SUBJECT: Cooke-Coleman Segregation (File # SEG-06-104)

DESCRIPTION: Segregation of 5 parcels into 9 parcels ((7) 20's and (2) 25.85 acre lots)

MEMORANDUM

SUBJECT: Cooke-Coleman LLC, SEG-06-104, 18-20-07000-0017, 0019, 0020, 0021, 0028

PART OF SECTION 7, TOWNSHIP 18 NORTH, RANGE 20 EAST, W.M.

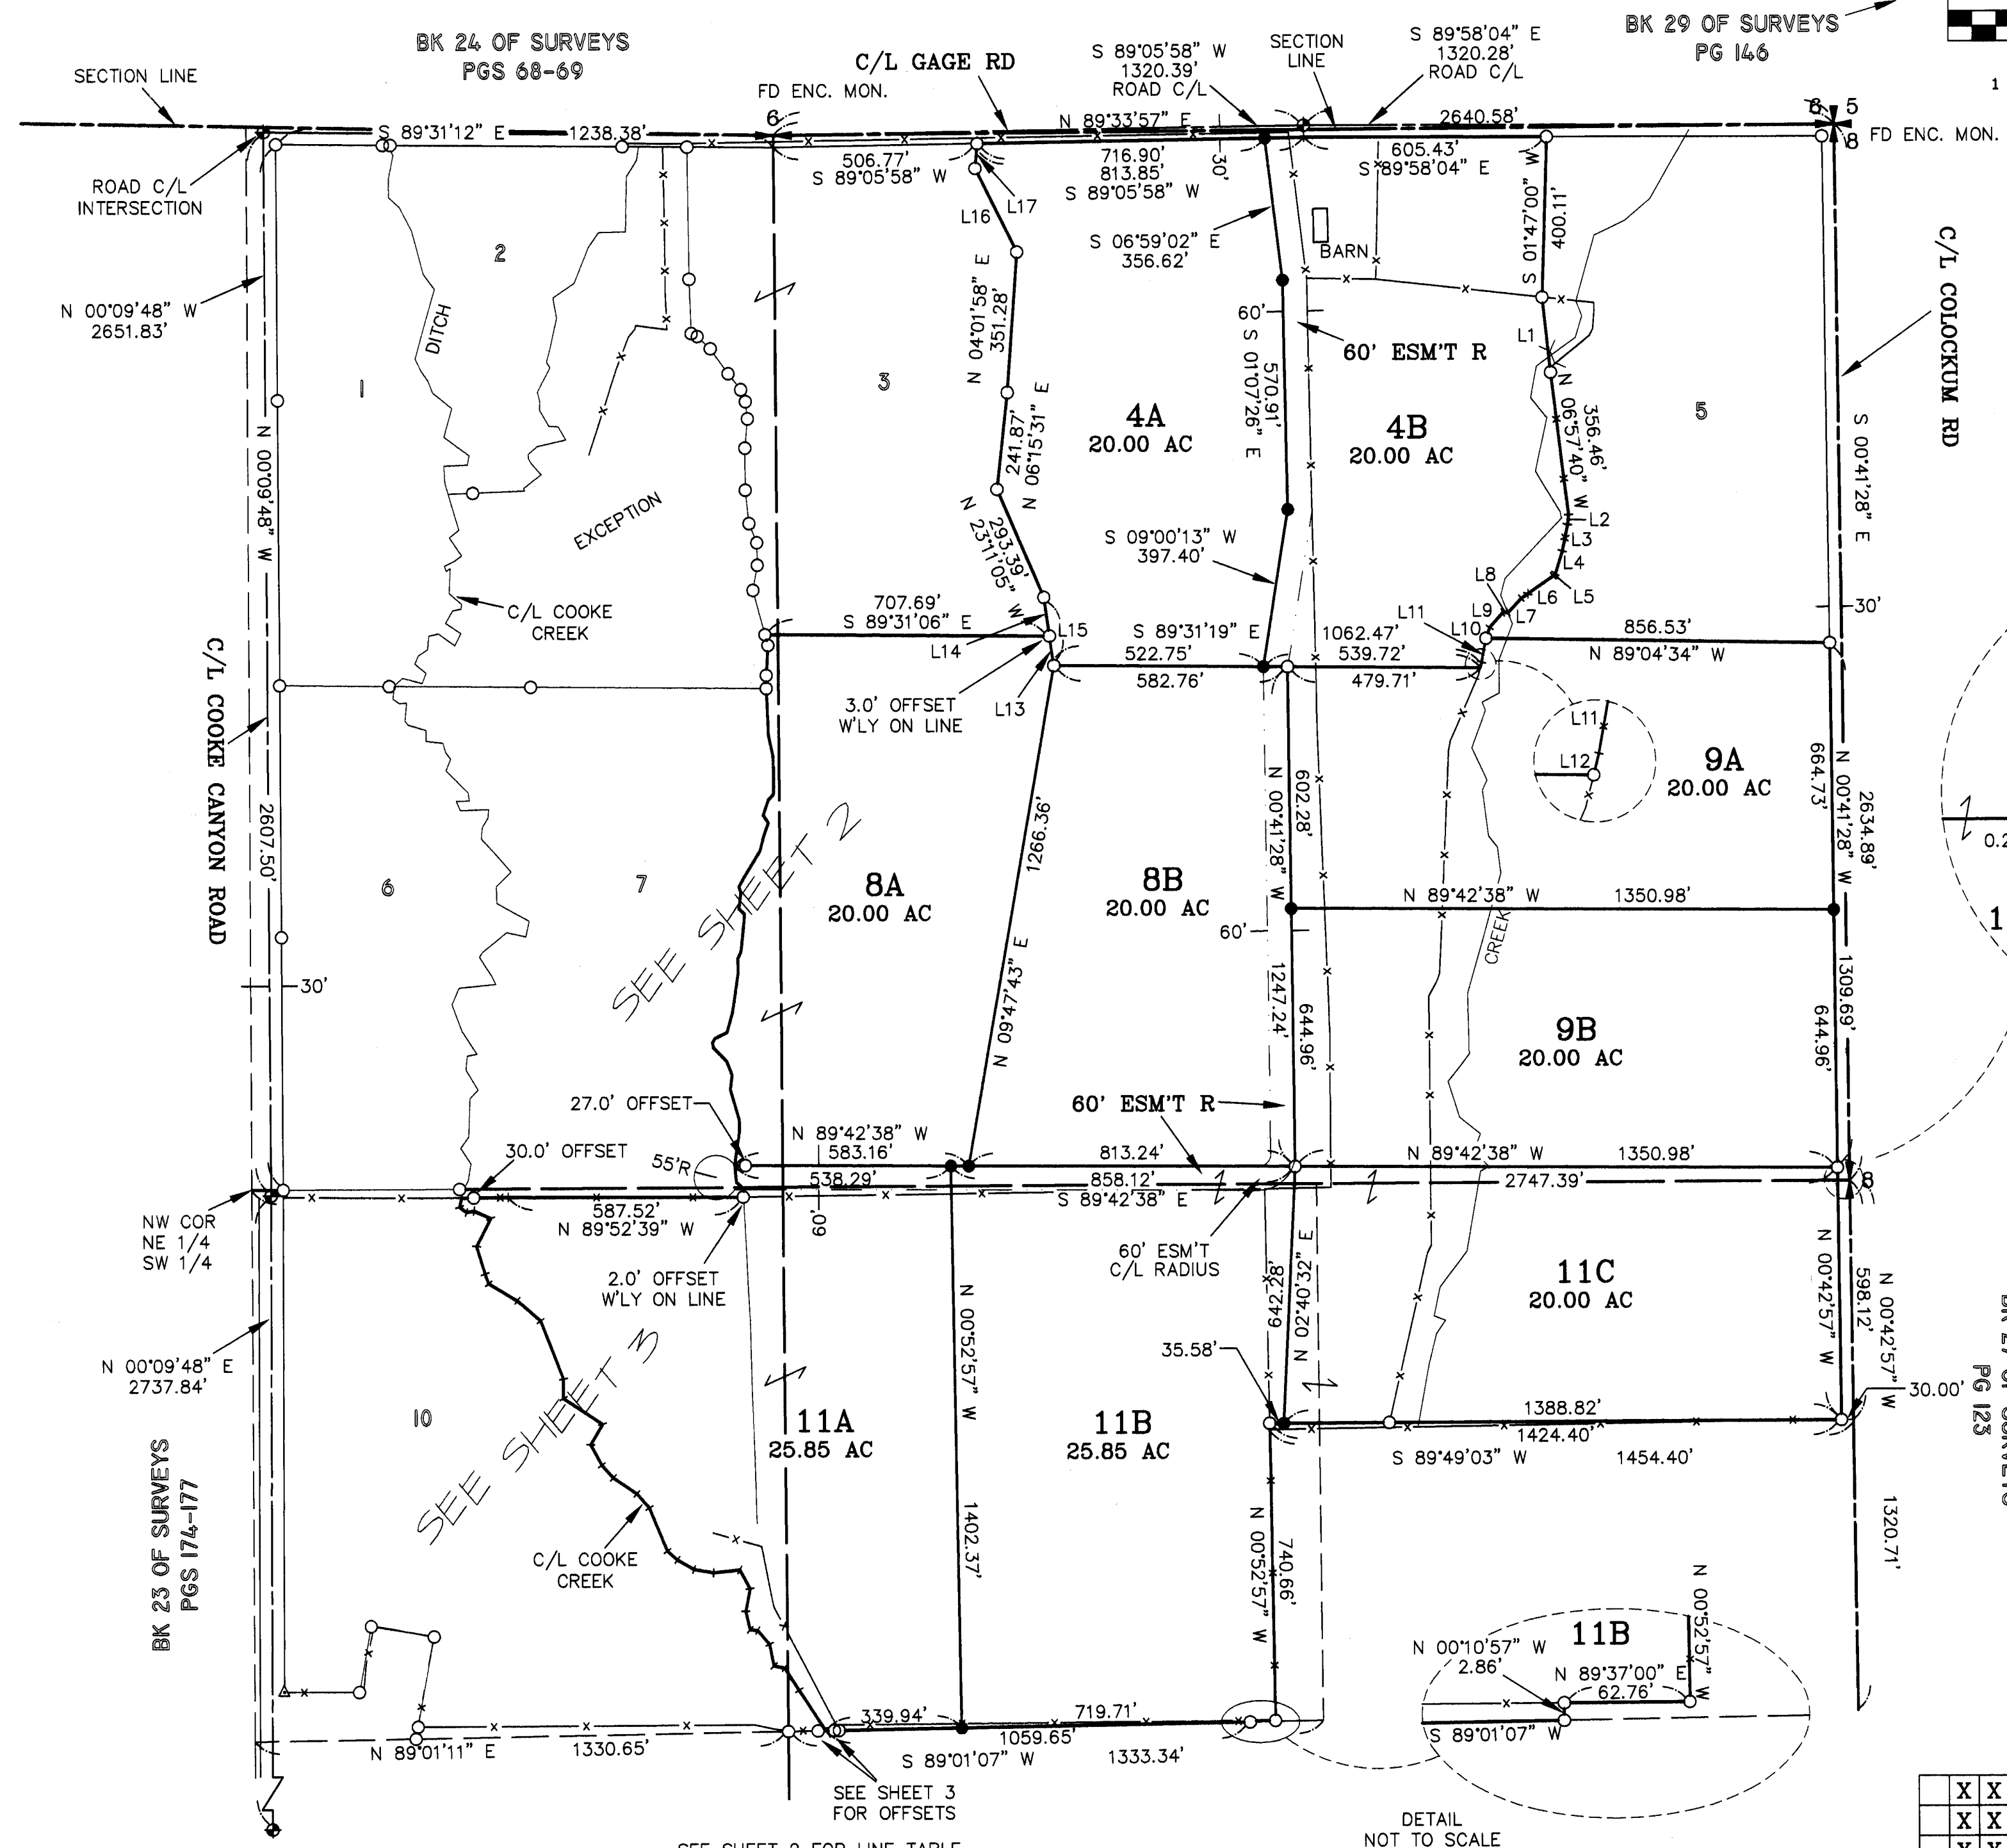
1. A survey of the proposed segregation must be received and approved.
2. Taxes must be paid in full for the lot stated above prior to final approval
3. Please see Kittitas County Public Works comment letter attached for additional information.

1. Prior to final approval the proposed access with appropriate easement(s) shall be shown and shall conform to applicable Kittitas County Road Standards.
